**Erosion Control Team
600 East Fourth Street
Charlotte, N C 28202-2844**

Rezoning Petition Review

Rezoning Petition #: 21-78

Proposed Zoning: R-8 MF (CD)

REZONING PLAN
RZ.01

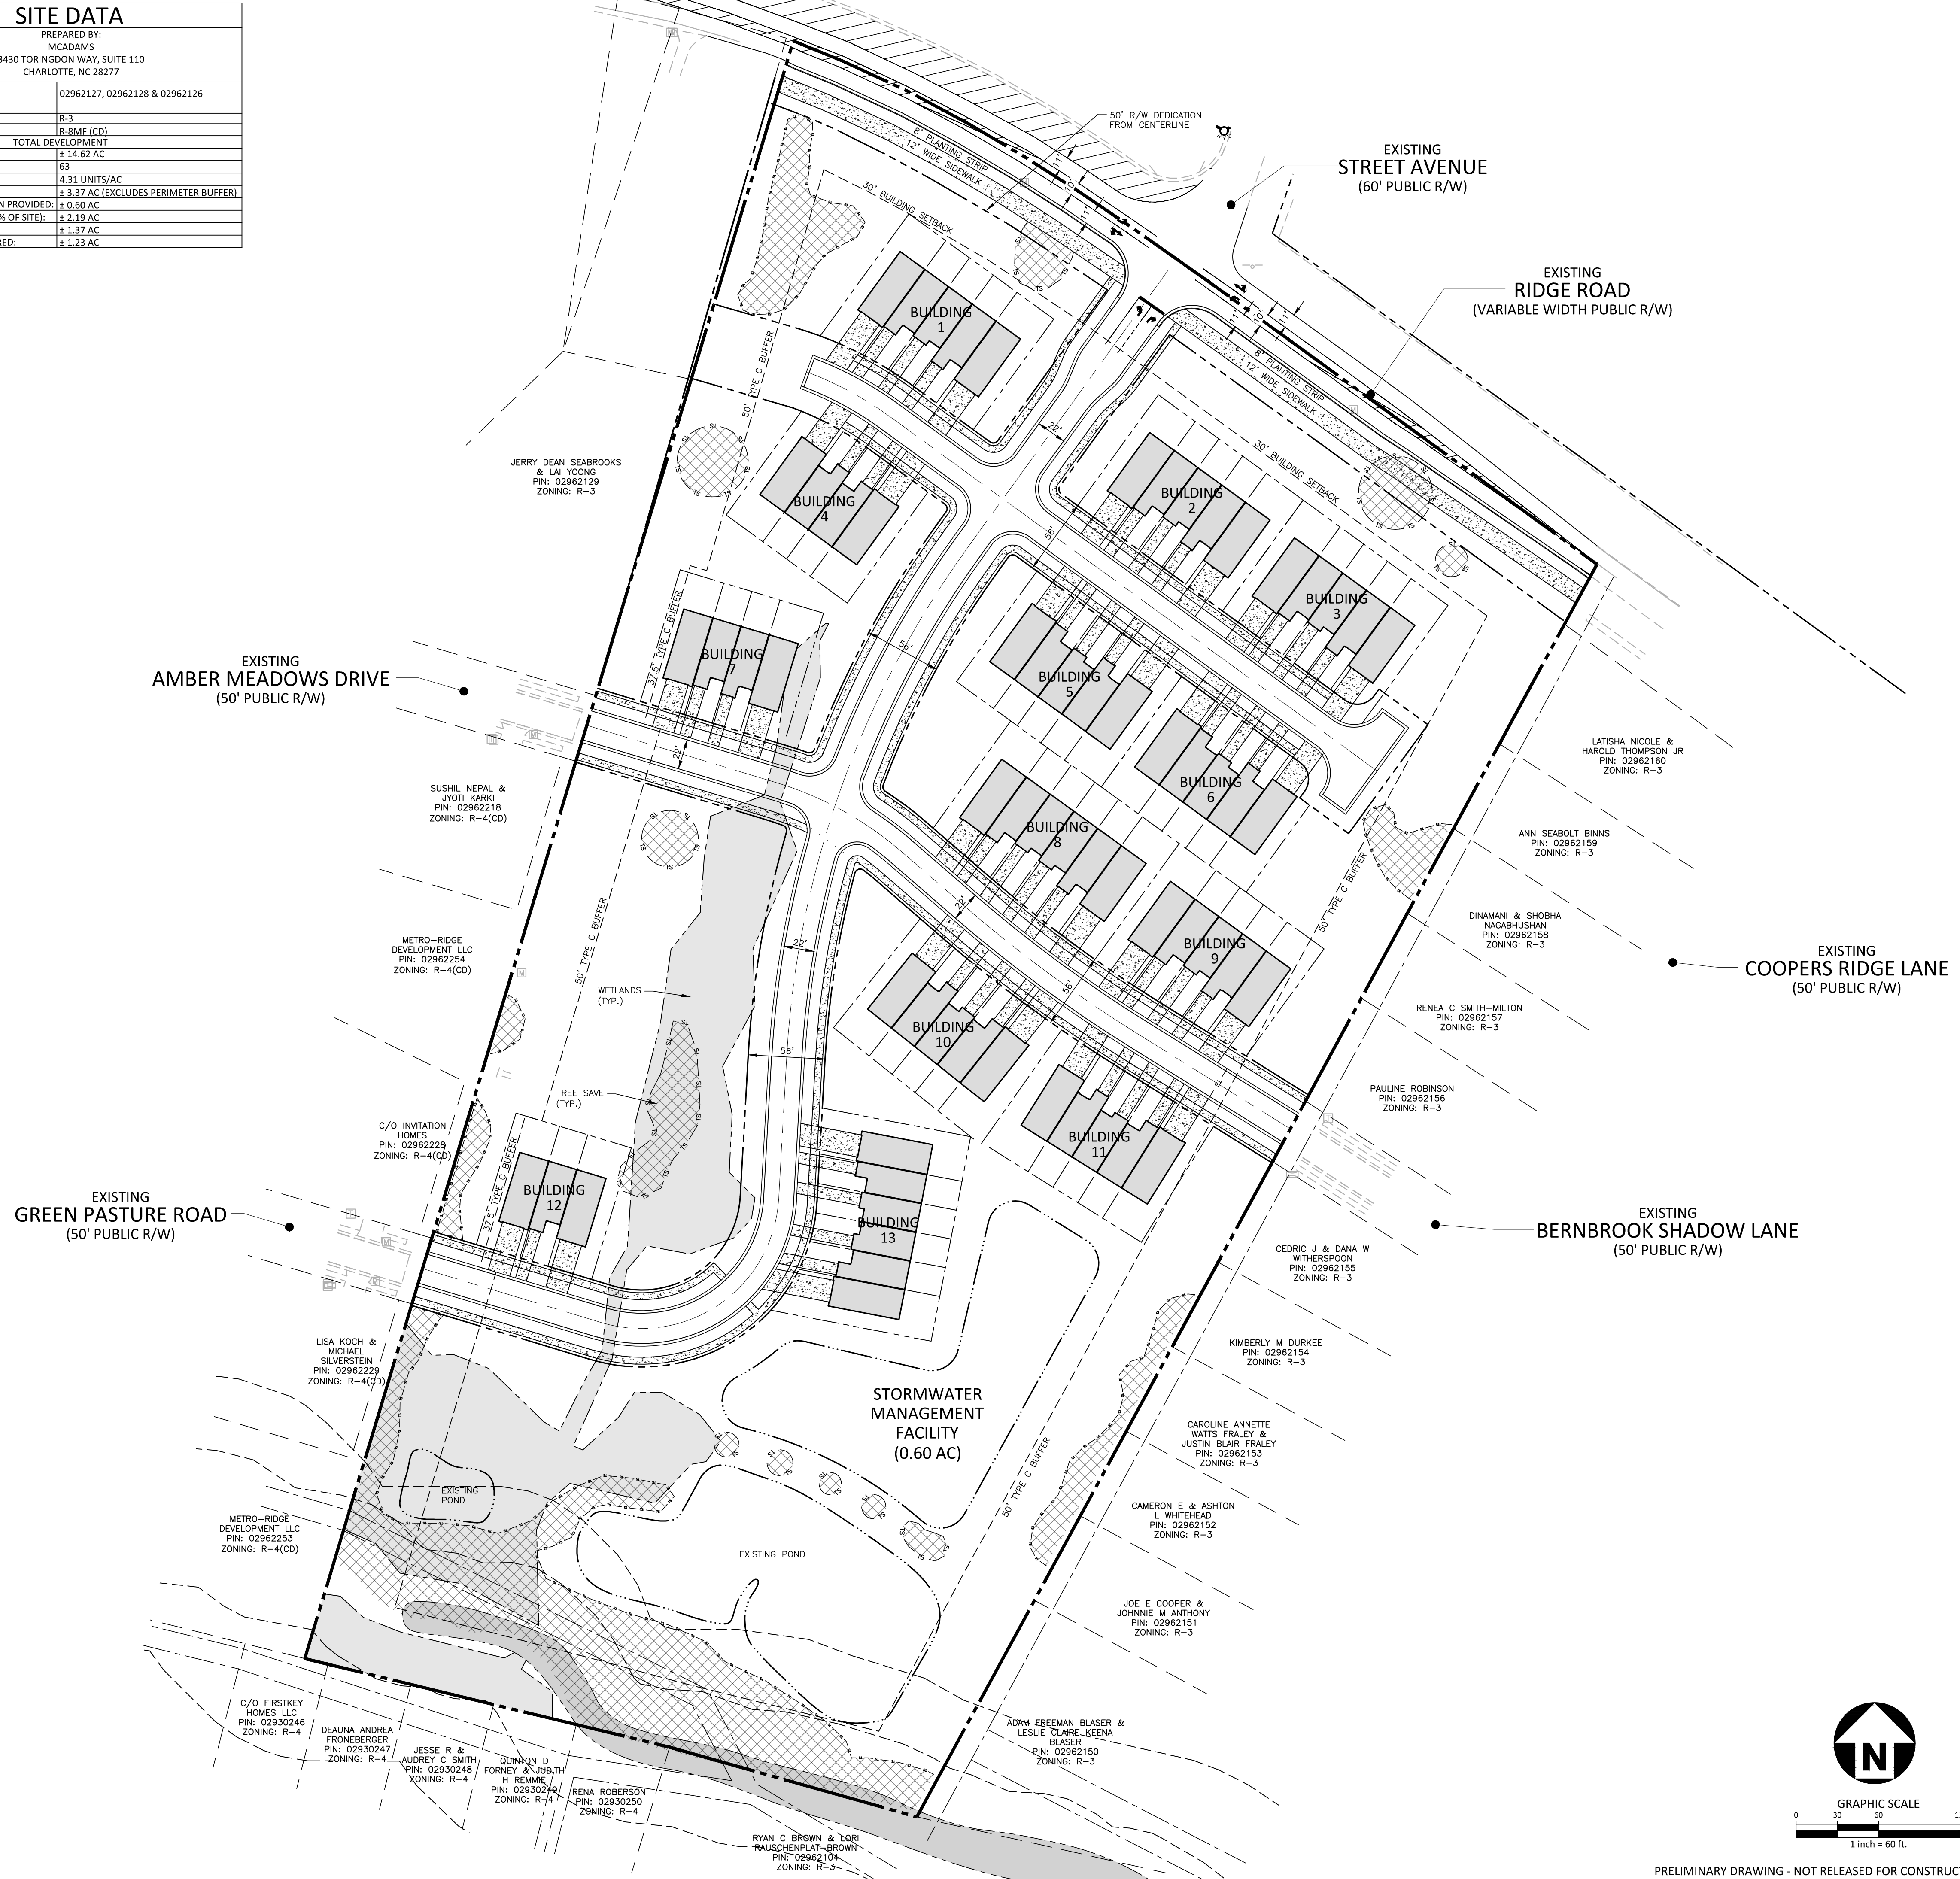
Drainage/Stormwater Management: Stream/wetland survey required prior to approval of civil site plan to ensure accurate delineation of top-of-bank/stream buffers/creek path and identification of any protected wetlands that may be on the site.
